**From:** Simon Davis  
**Sent:** 28 May 2019 13:17  
**To:** Planning.Responses  
**Subject:** FW: BE/58/19/RES The Cottage, Shripney Road Phase 1  
**Attachments:** 6656 004\_E - Proposed Site Plan - New Dwelling.pdf

**From:** Ben Daines [REDACTED]  
**Sent:** 24 May 2019 16:58  
**To:** Simon Davis [REDACTED]  
**Cc:** Chris Barker [REDACTED]  
**Subject:** RE: BE/58/19/RES The Cottage, Shripney Road Phase 1

Drawing Title
Proposed Site Plan
New Dwelling

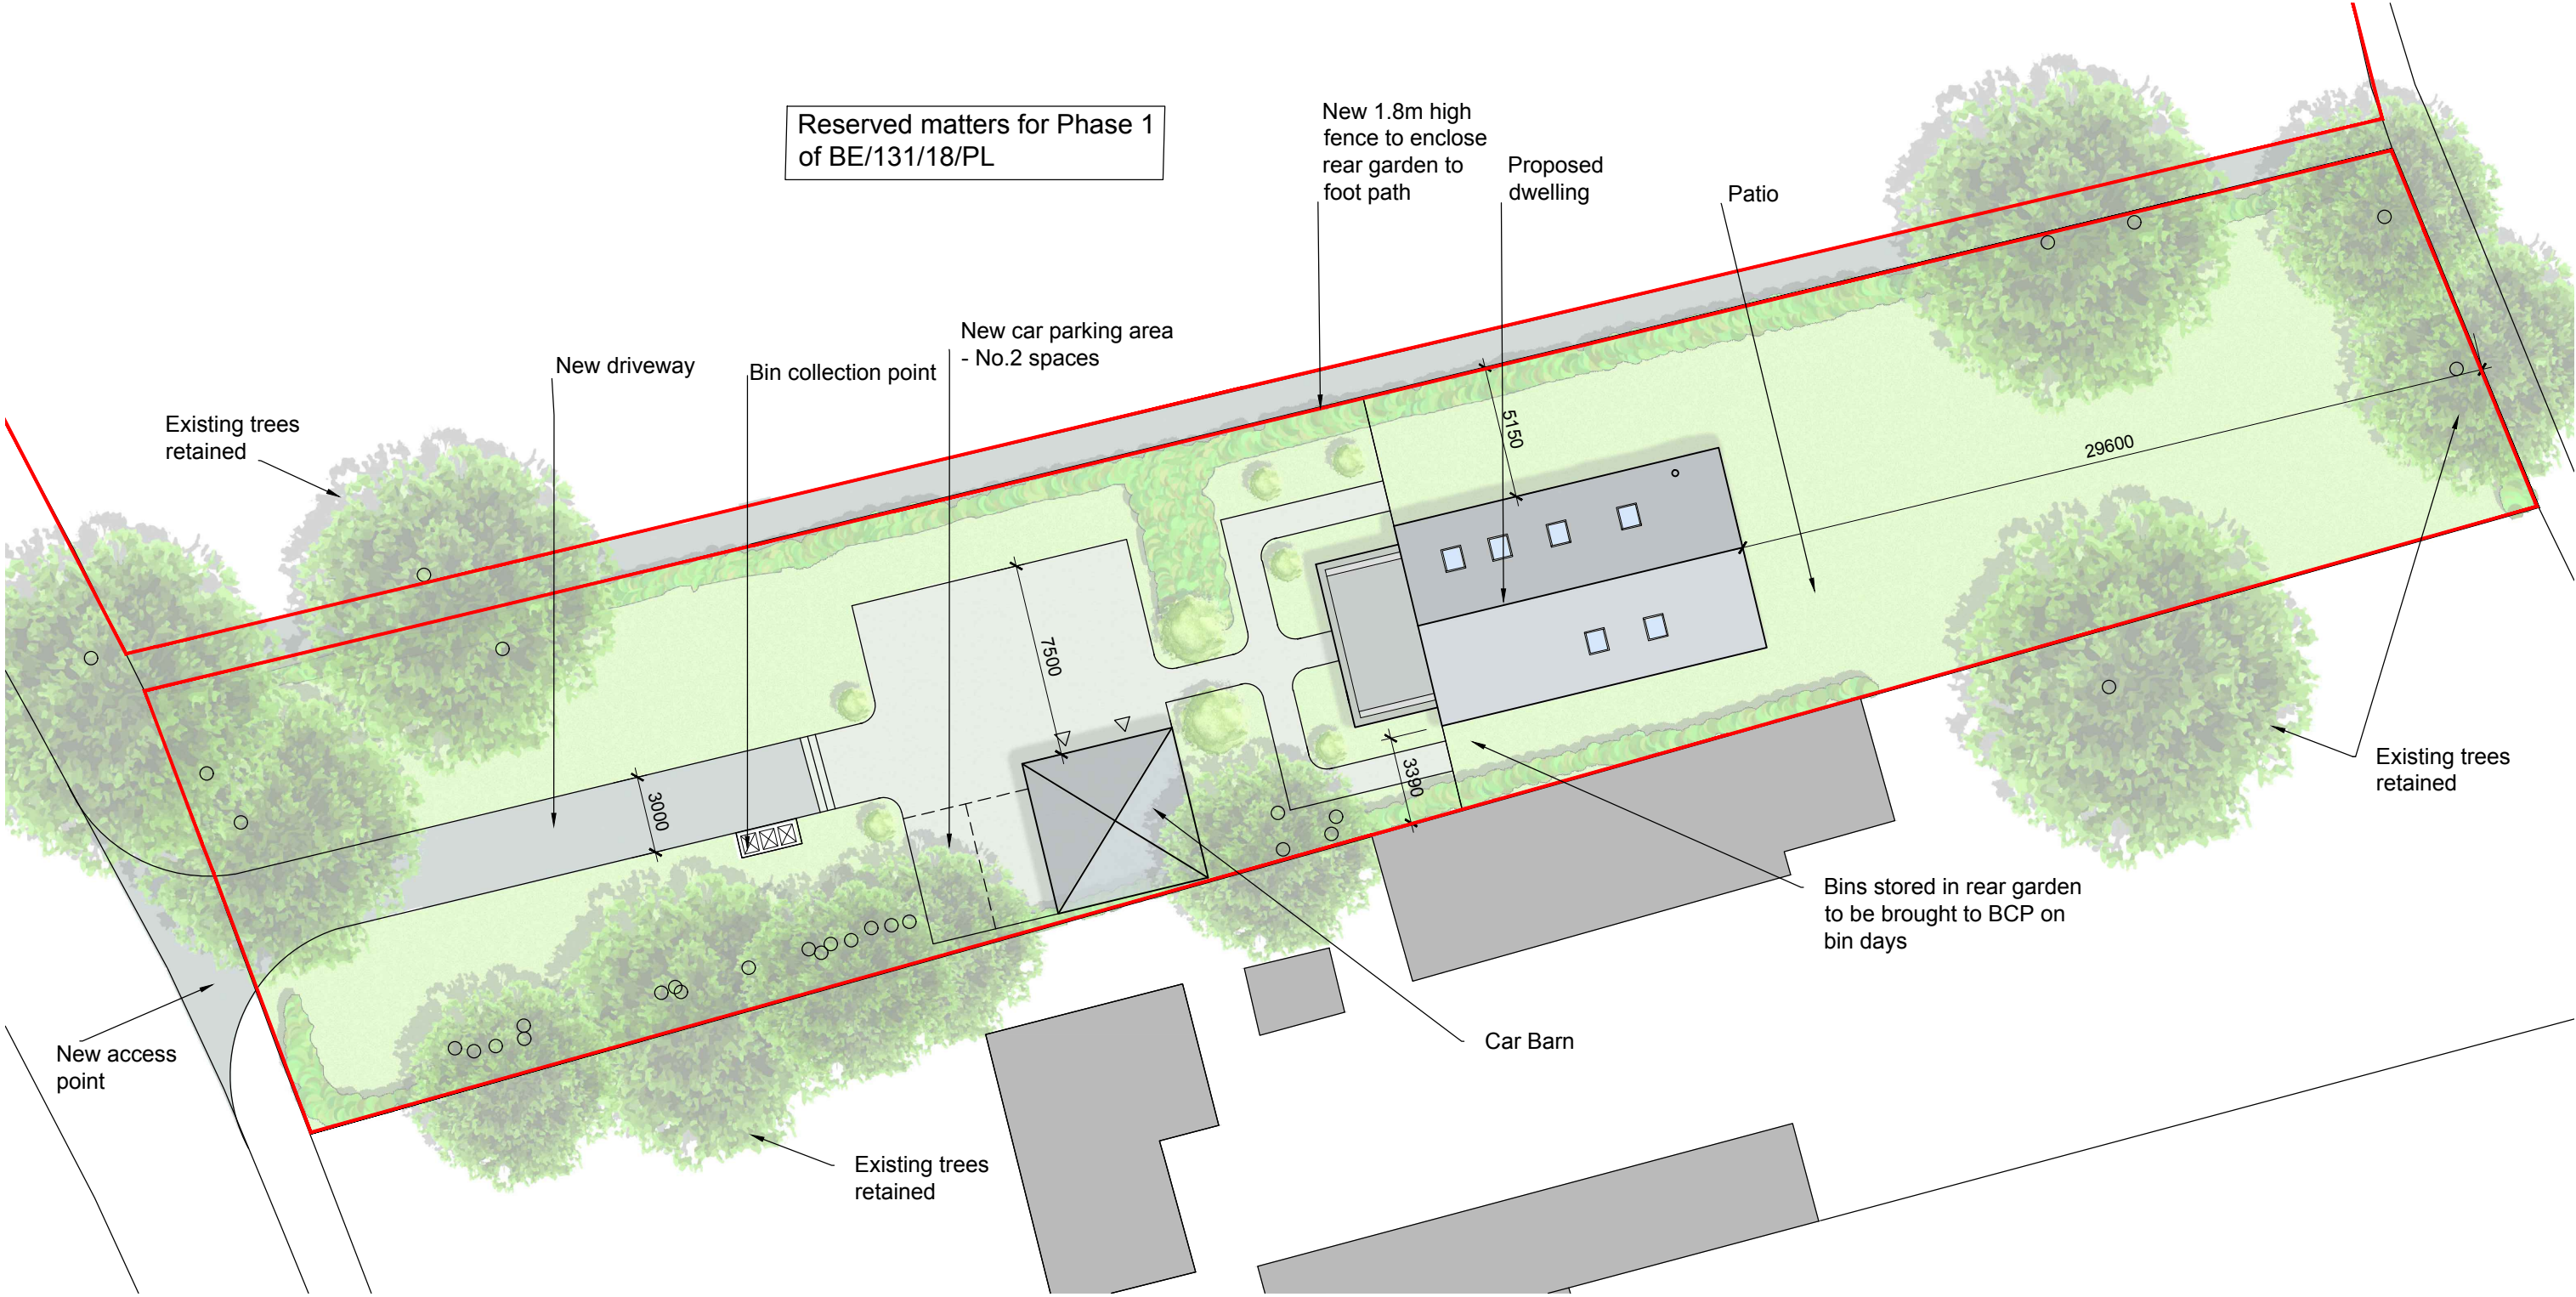
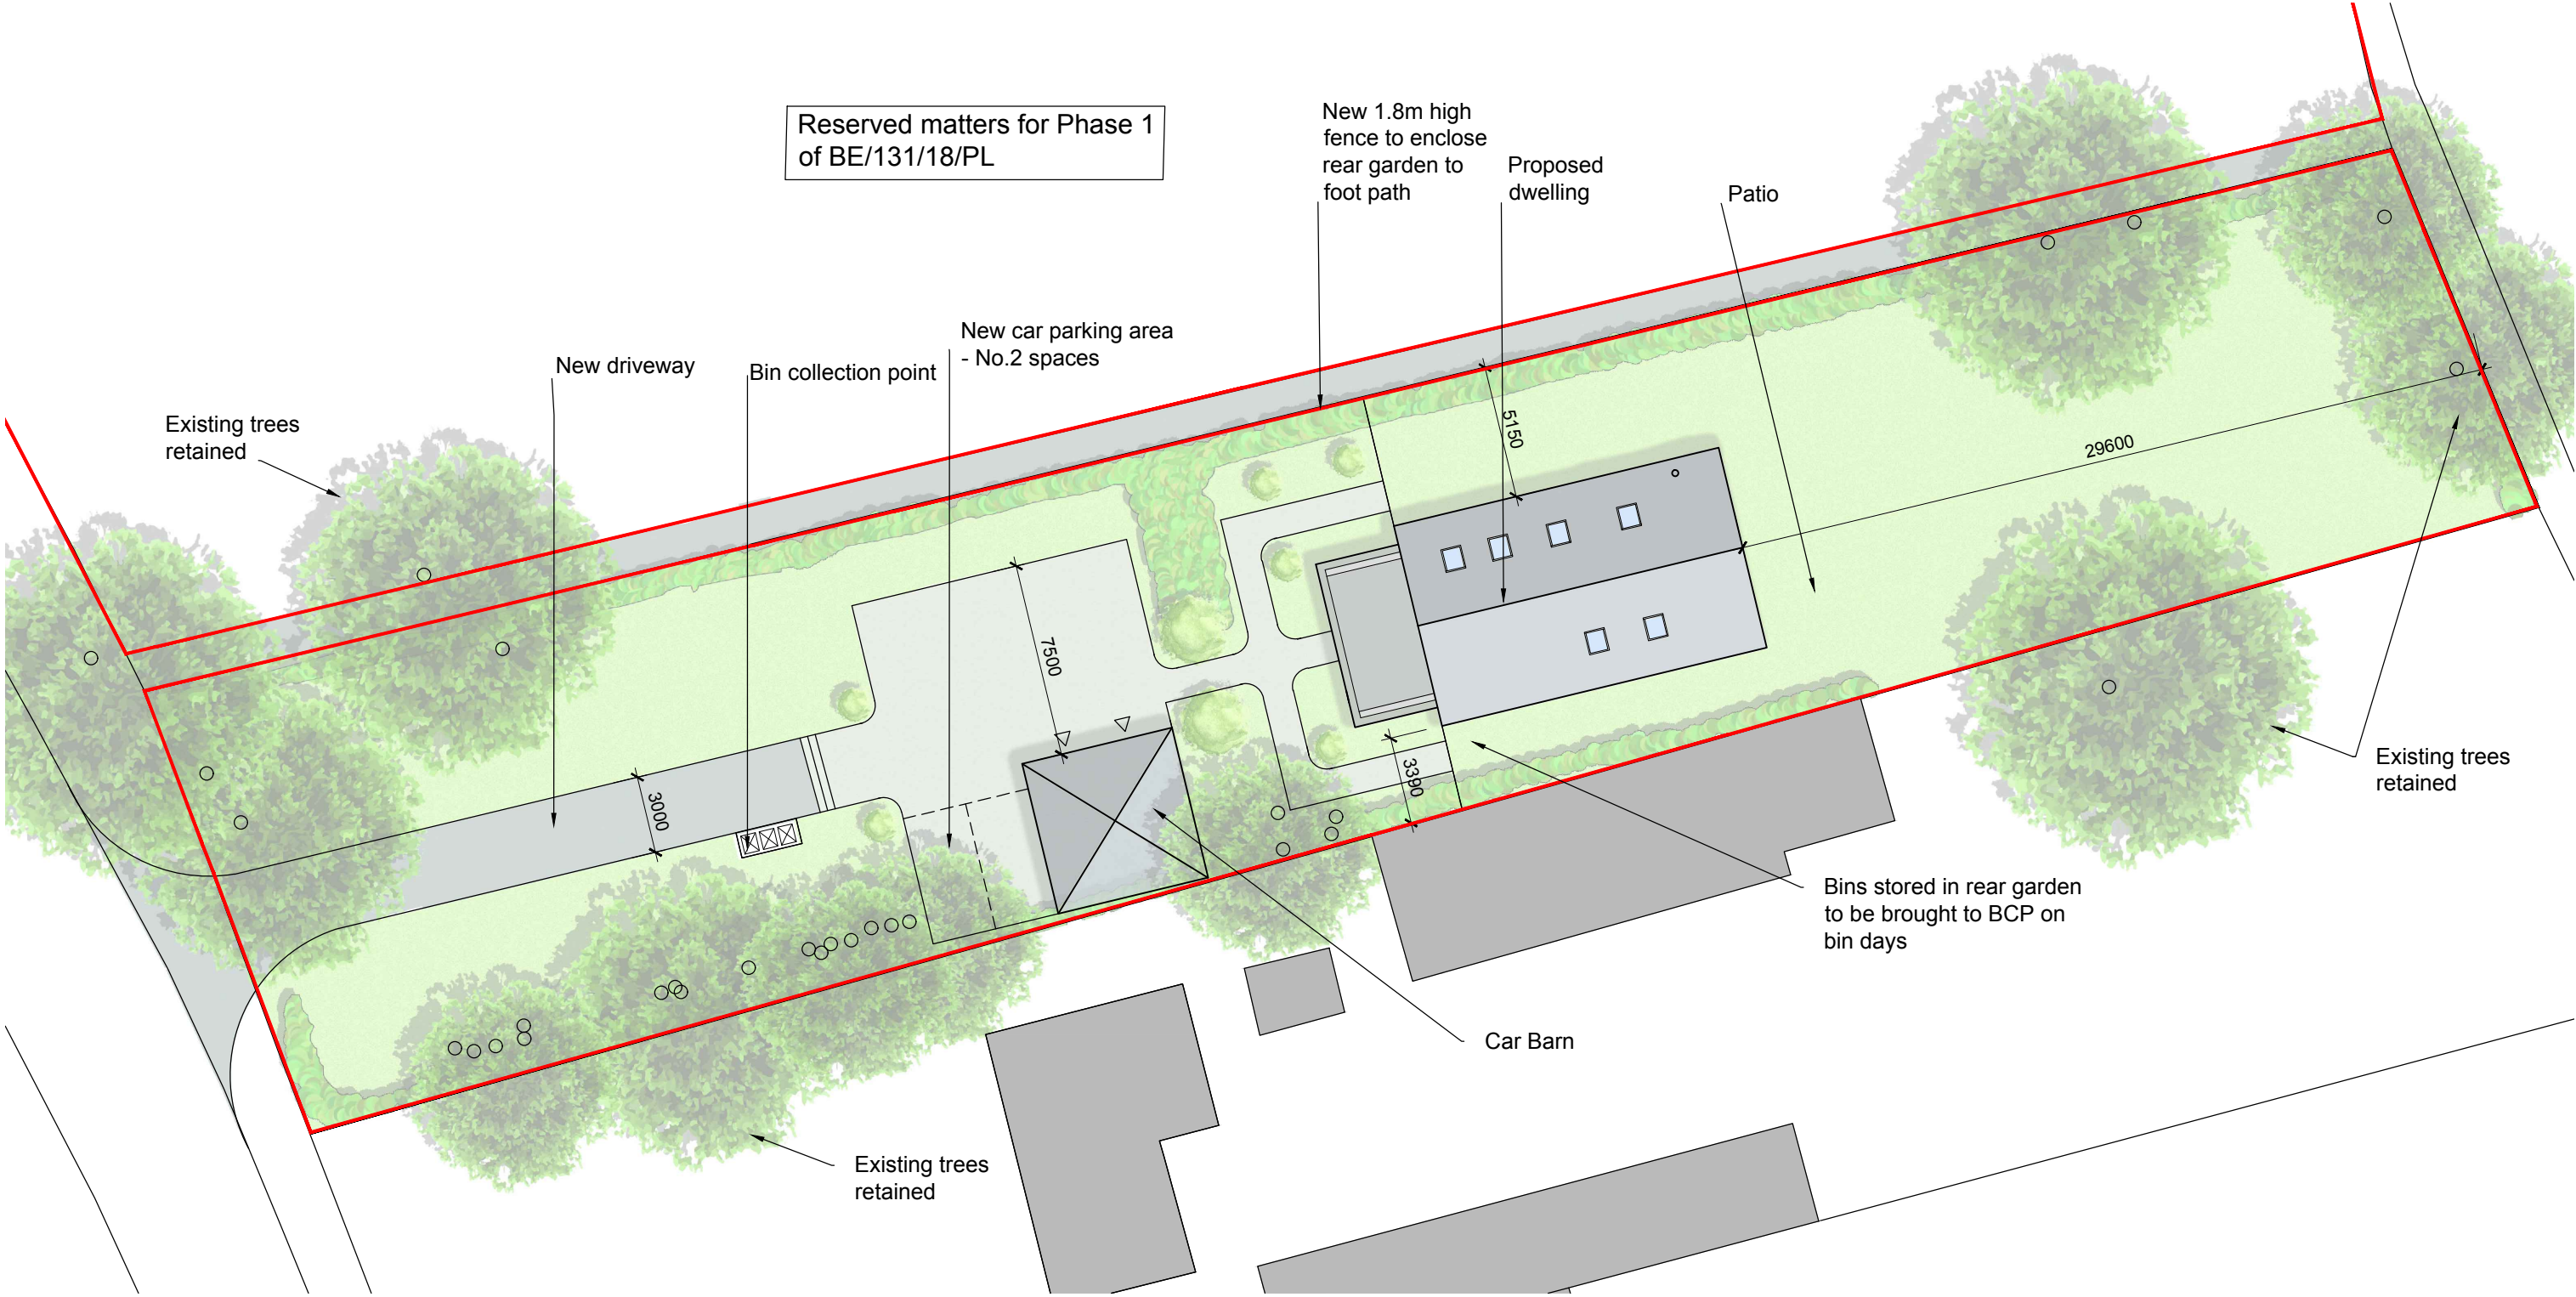
Yes I think it would be helpful and avoid any confusion down the line if you could amend the plan to change the annotation.

Sorry, this was an error. It is proposed to upgrade the existing cross over point in accordance with the approved outline application rather than provide a new access point.

With reference to our correspondence yesterday, please find attached a revised site plan which no longer refers to a new access.
